MESA DEL SOL
ARCHITECTURAL CONTROL COMMITTEE
SITE DEVELOPMENT PLAN REVIEW

**RE: Mesa Del Sol Self Storage
5500 Turing Dr. SE
Grading and Drainage Plan
Engineer's Stamp Date: 5/7/2025
Hydrology File: R16DA1004**

**Re: Mesa Del Sol Self Storage
 5500 Turing Dr. SE
 Grading and Drainage Plan
 Engineer's Stamp Date: 01/15/2025
 Hydrology File: R16DA1004**

Here are the responses to the comments provided on March 21, 2025 in regards to an **Updated Grading & Drainage prior to continuing onsite grading and foundation work.**

6
C-3.0

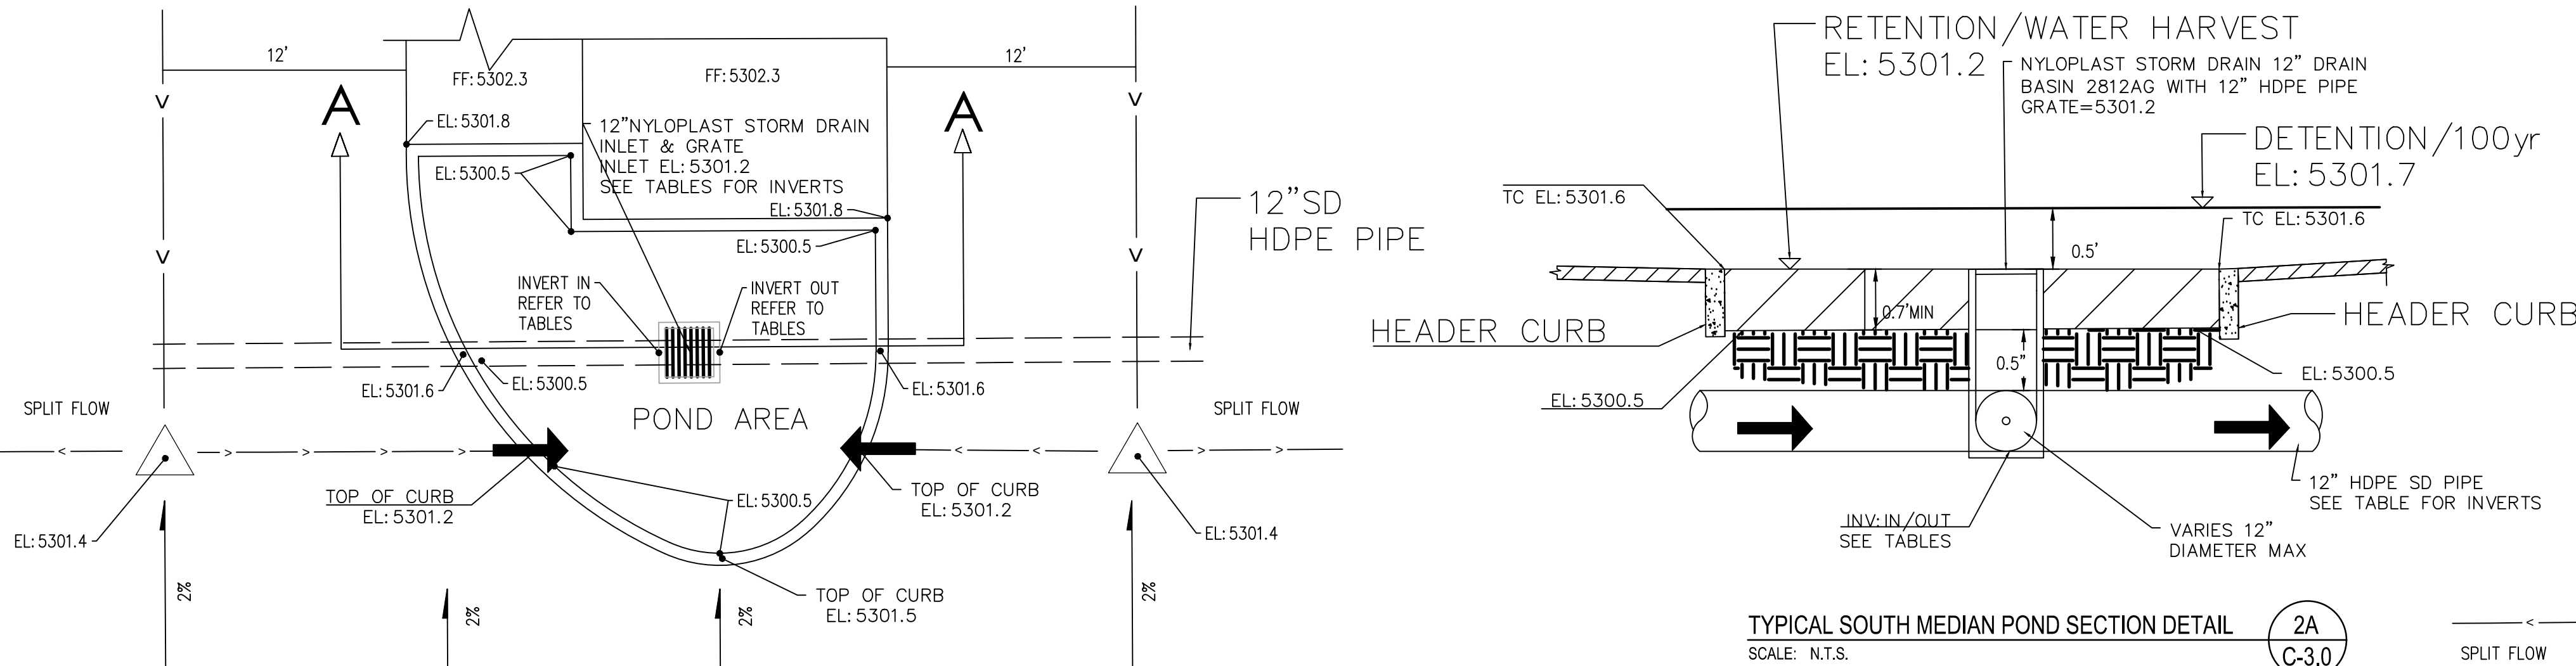
6. Any and all proposals should be presented and demonstrated appropriately on an Updated Grading & Drainage Plan.
Concur. See revised Grading Plan and Details.

C-3.0

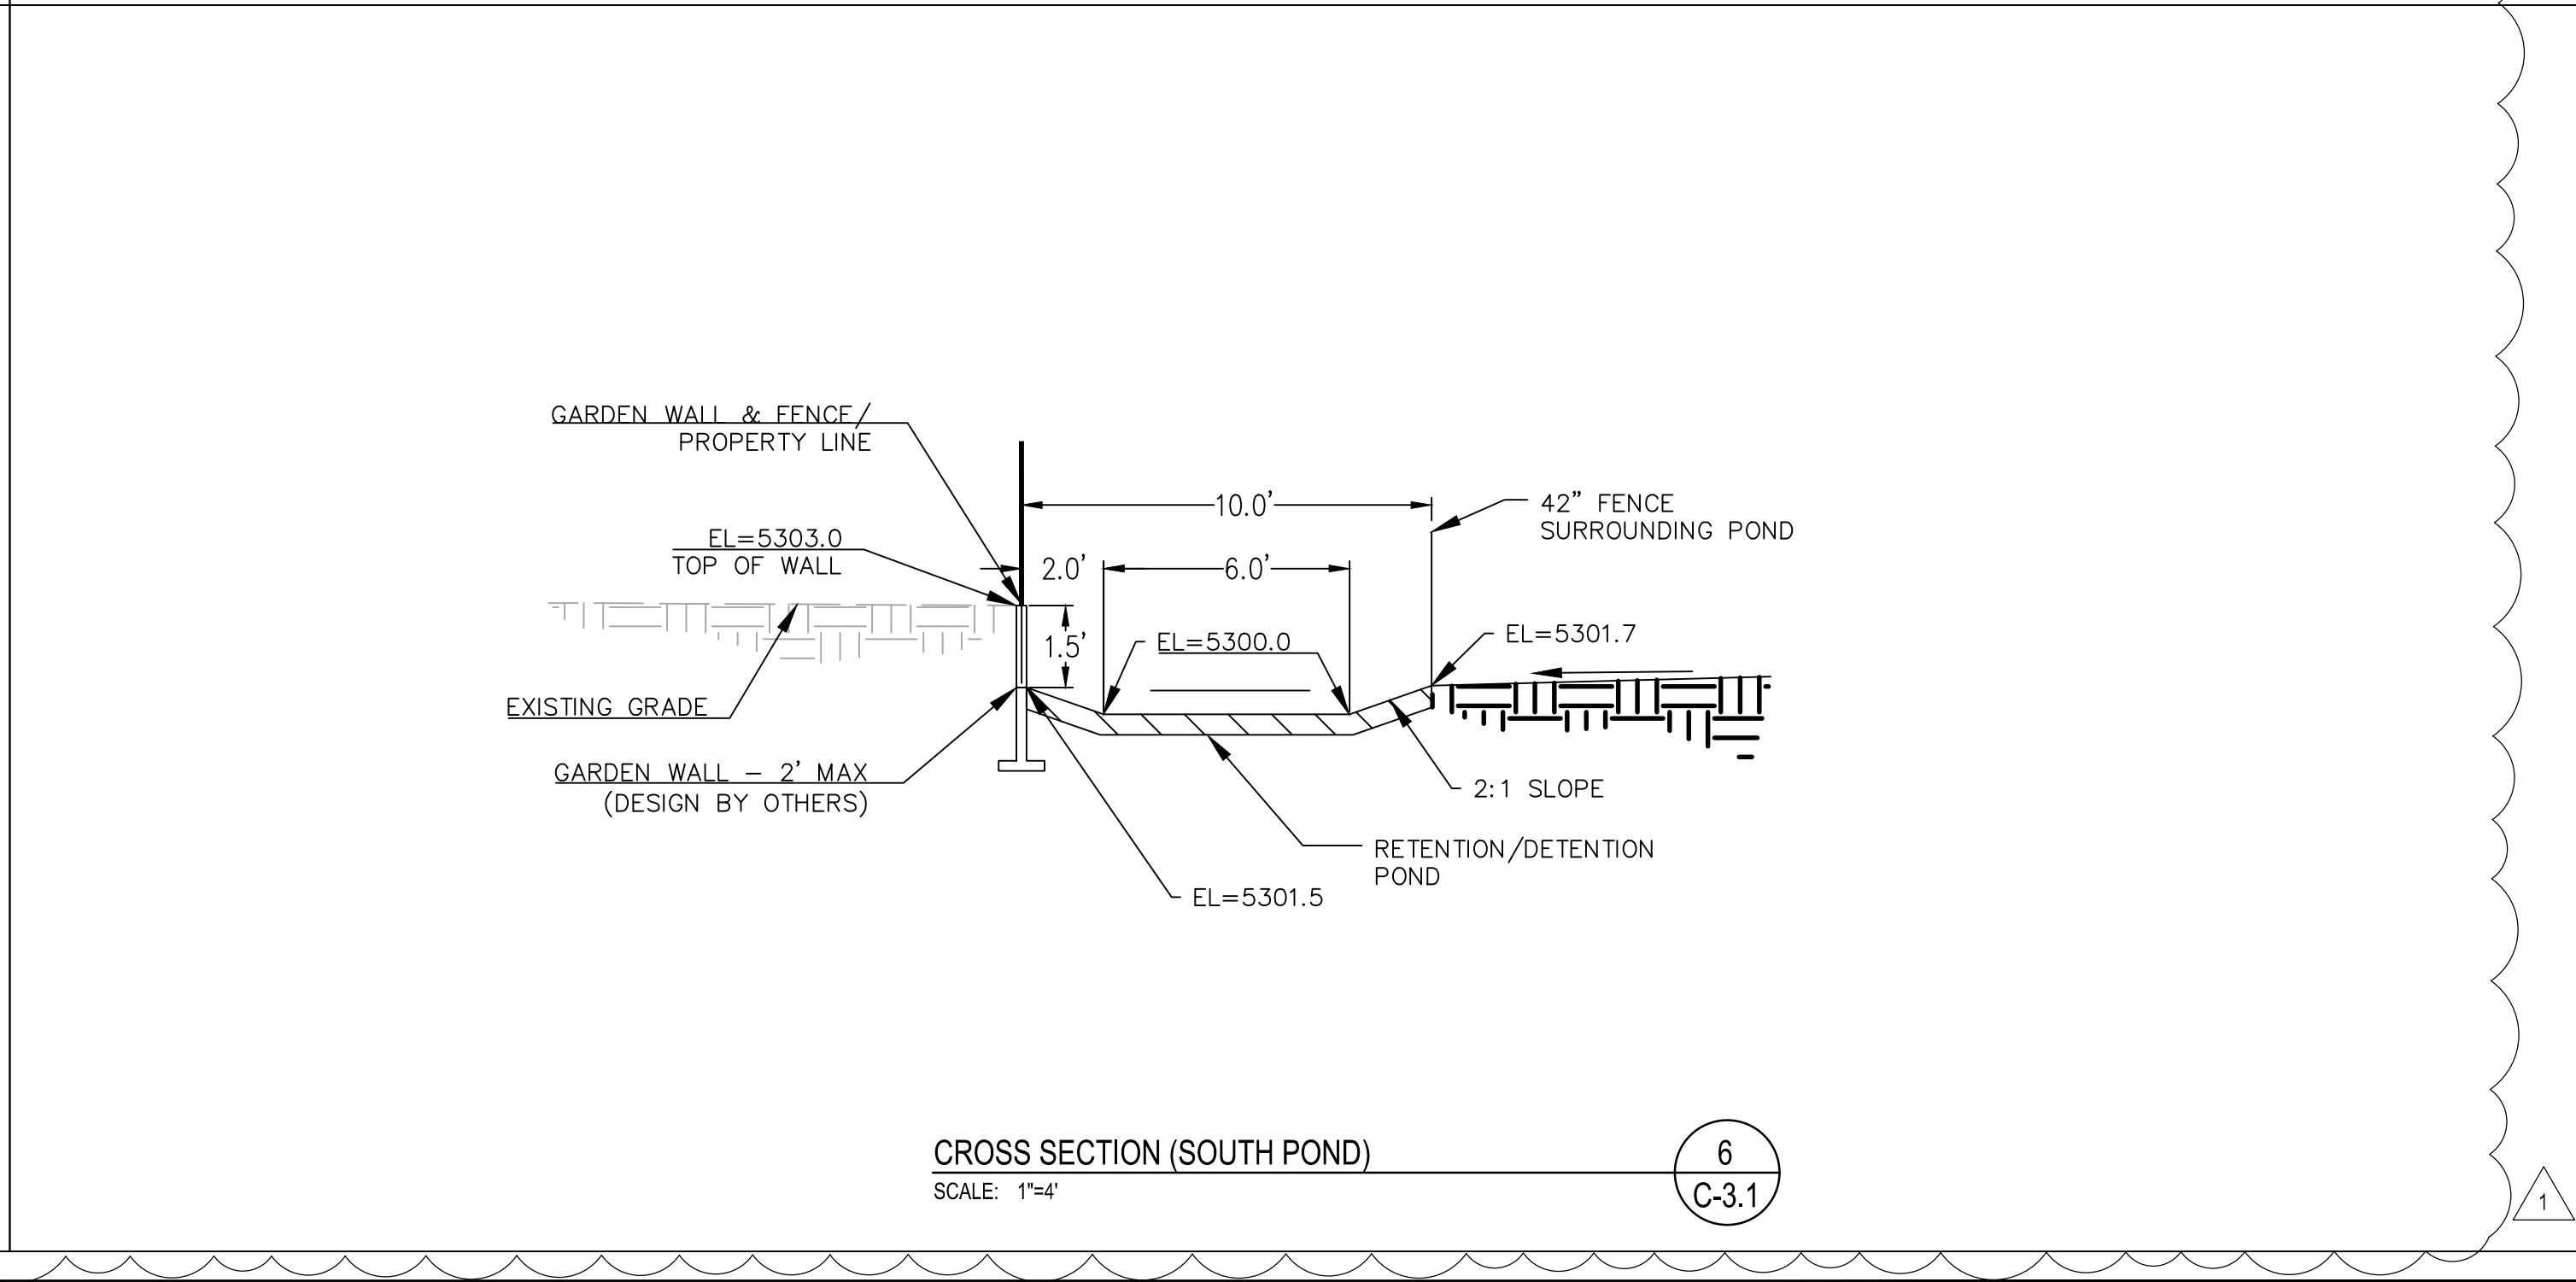
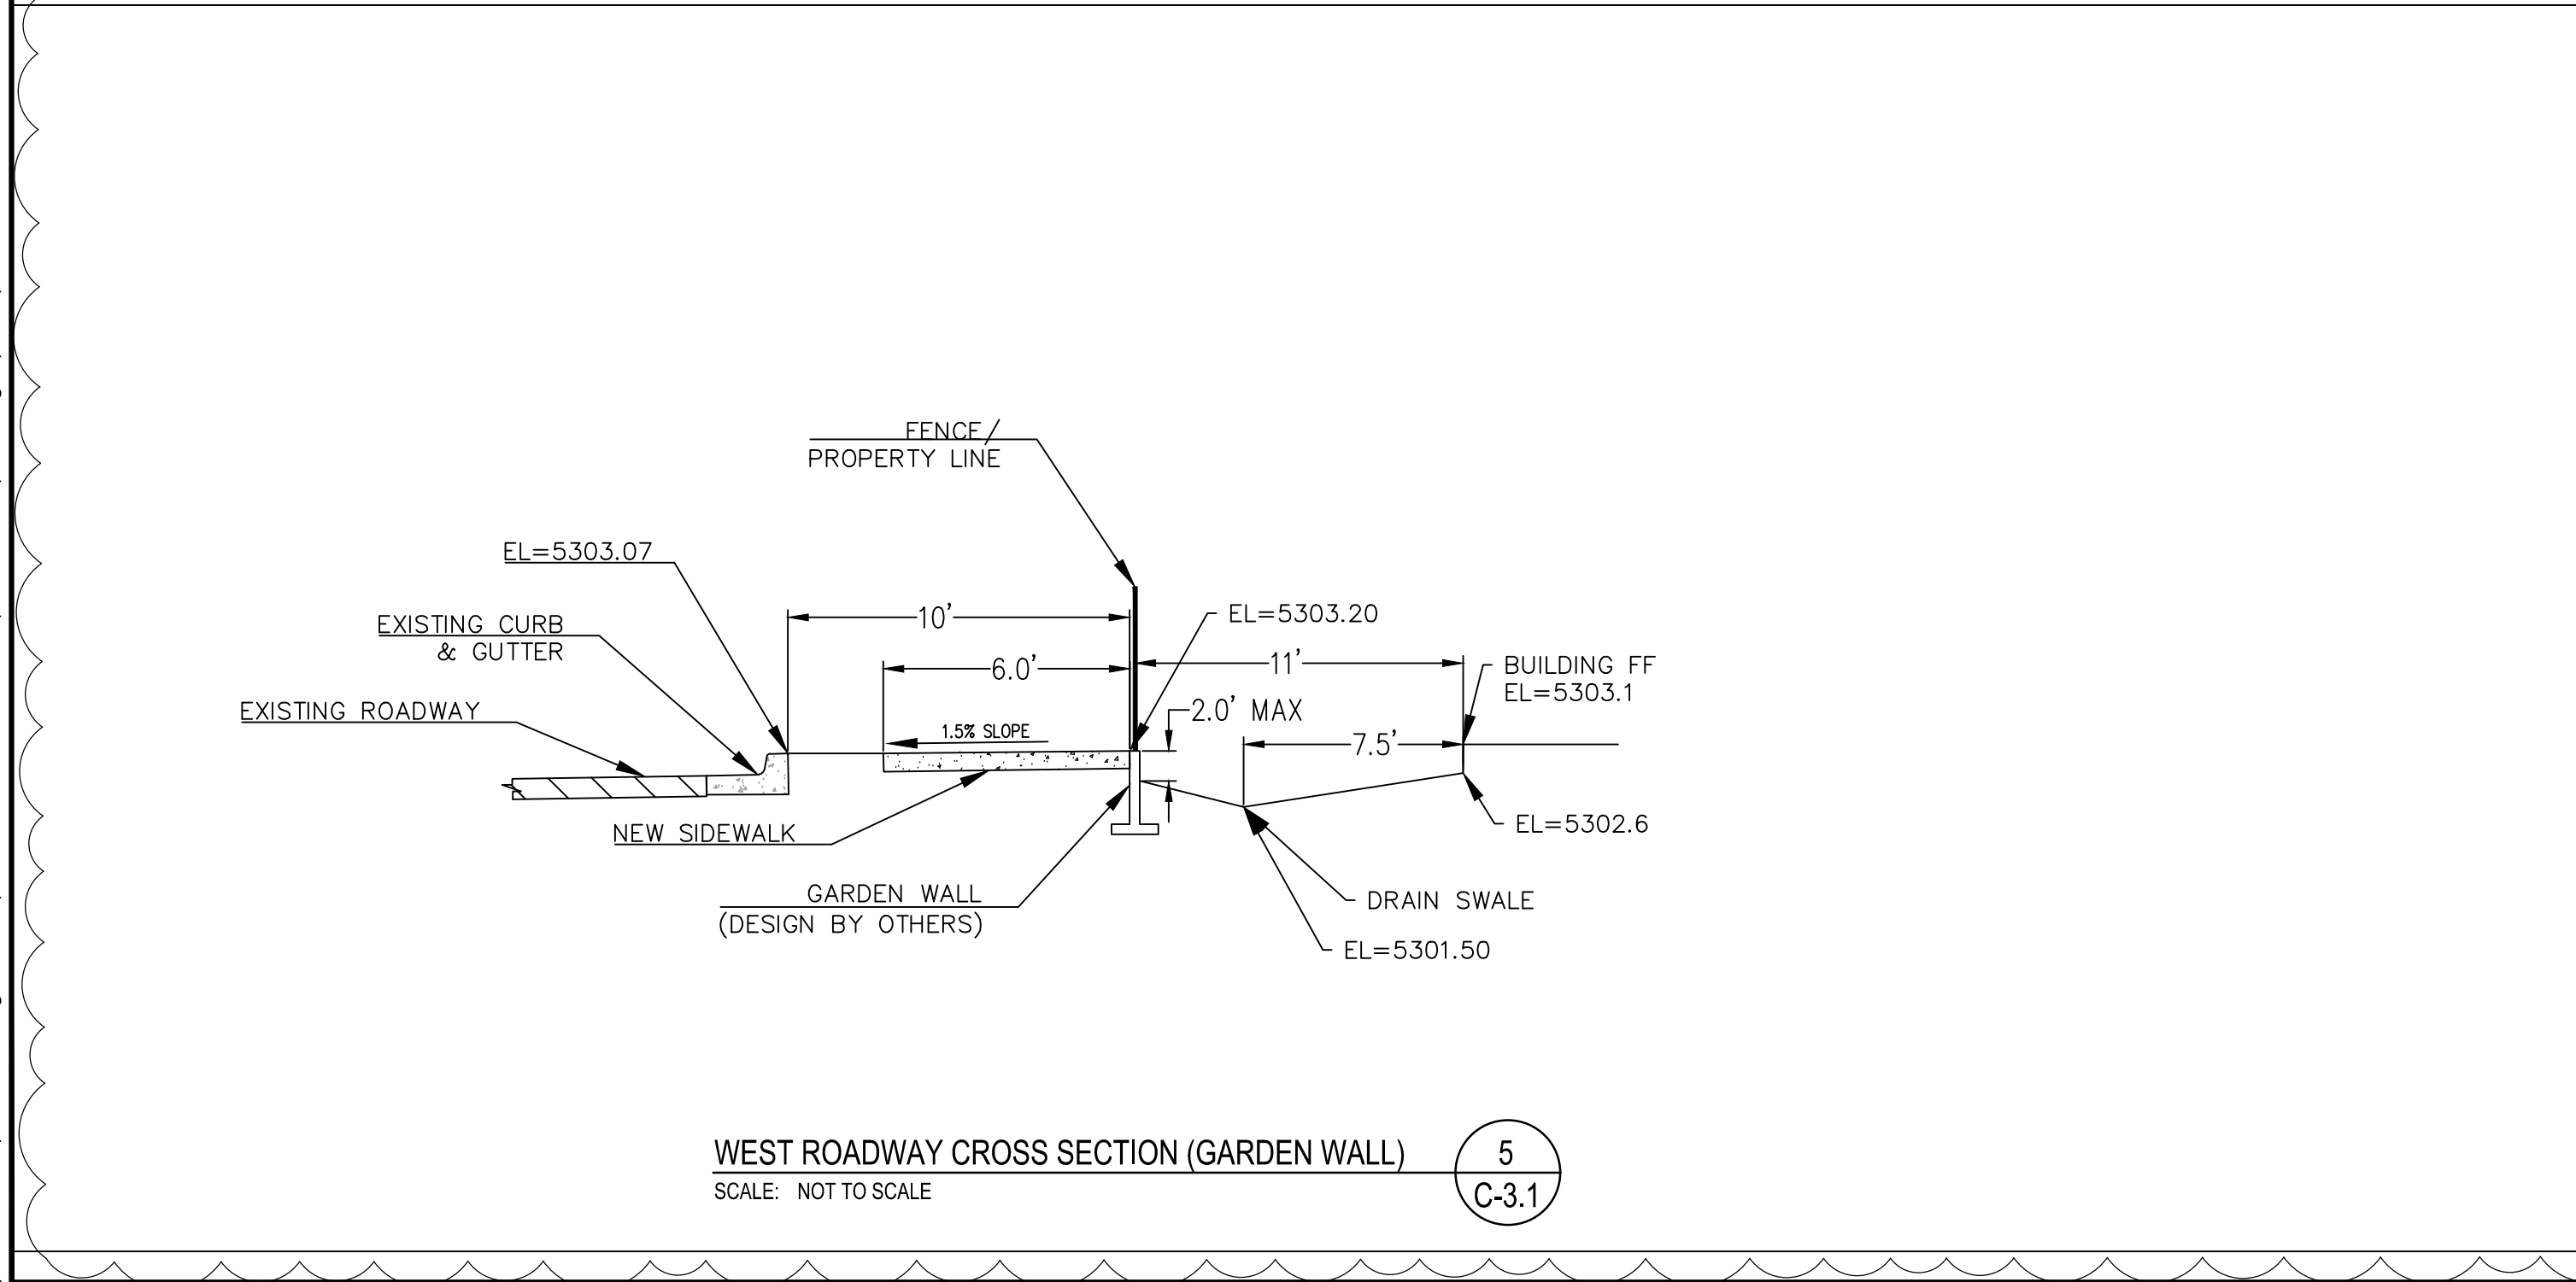
8. Due to the proposed retaining wall in Section 1 of C-3.1, provide an additional cross-section showing the existing storm drain manhole and pipe extension through the proposed retaining wall and into the retention basin at the southeast corner of the project.
Concur. Additional section has been added, see revised sheet C-3.1 & C-3.2. Retaining wall removed from revised design.
